KITTITAS COUNTY FIRE MARSHAL'S OFFICE

October 5, 2012

Re: Back Country (BL-12-00025)

RECORD OF SURVEY
 A PORTION OF THE WEST 1/2 OF SECTION 7,
 TOWNSHIP 19 NORTH, RANGE 15 EAST, W.M.,
 KITTITAS COUNTY, WASHINGTON

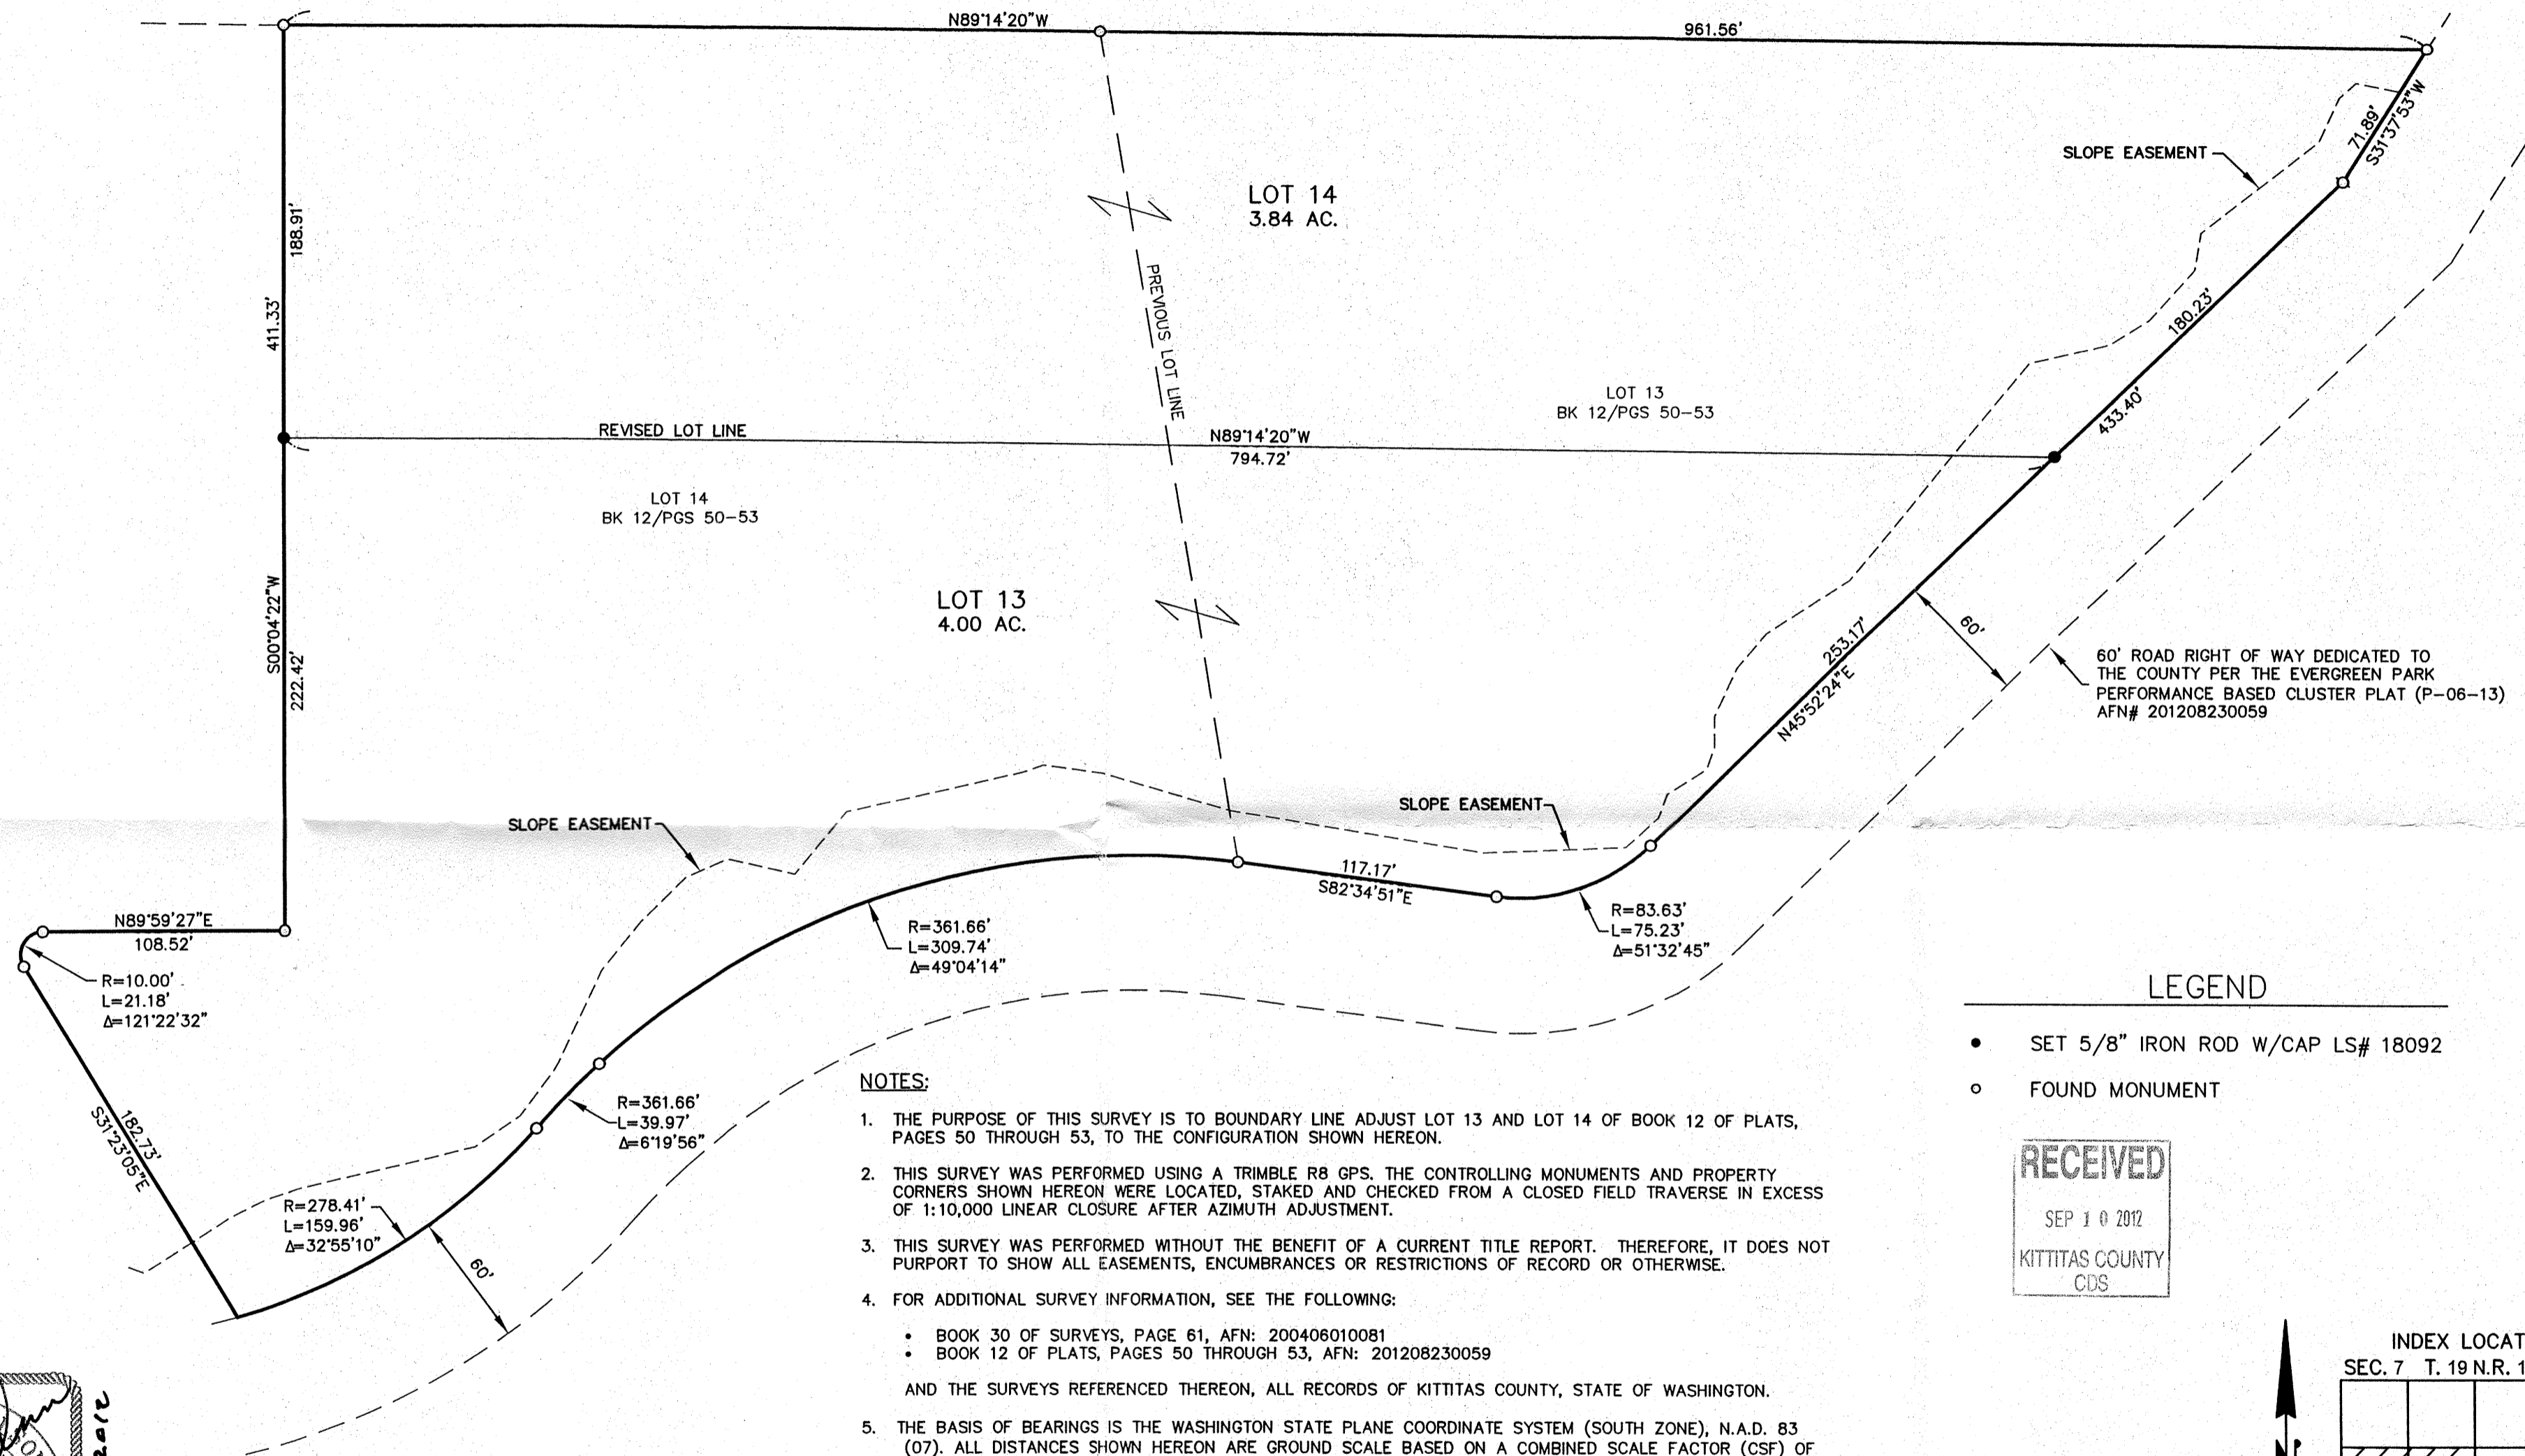
- Ensure that boundary line adjustments do not infringe upon existing structures, to include propane tanks, etc.
- All future development must comply with the International Fire Code.
